From: Simon Davis
Sent: 12 March 2019 12:04
To: Planning.Responses
Subject: FW: Y/49/18 Land east of, North End Road, Yapton, Arundel

A query has been raised by our Group Head of Planning on this application. He wanted to make sure that the proposed visibility splay is achievable either through their or County ownership. I note that the TS states that the

Tree protection plan

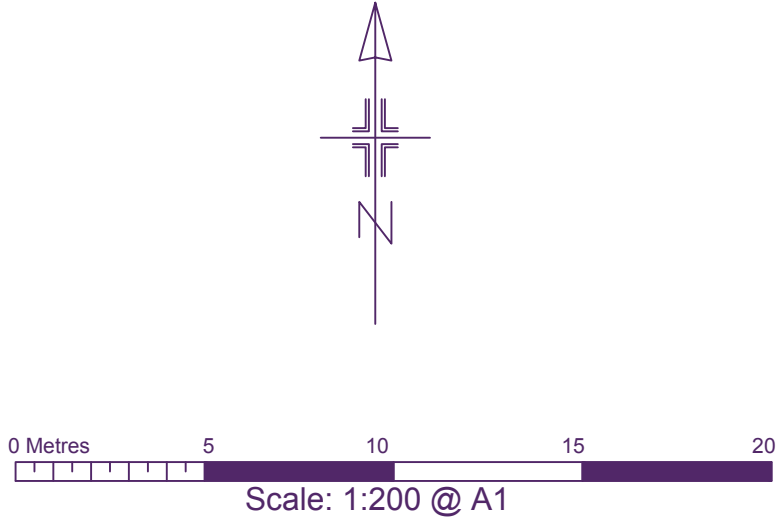
Hi Simon – apologies for not getting back to you sooner. The visibility splays here runs through the laurel hedge and therefore this would need to be kept lower than 0.6m, if it is within their ownership this would need to be conditioned to ensure the hedge does not grow higher than this and obscure visibility.
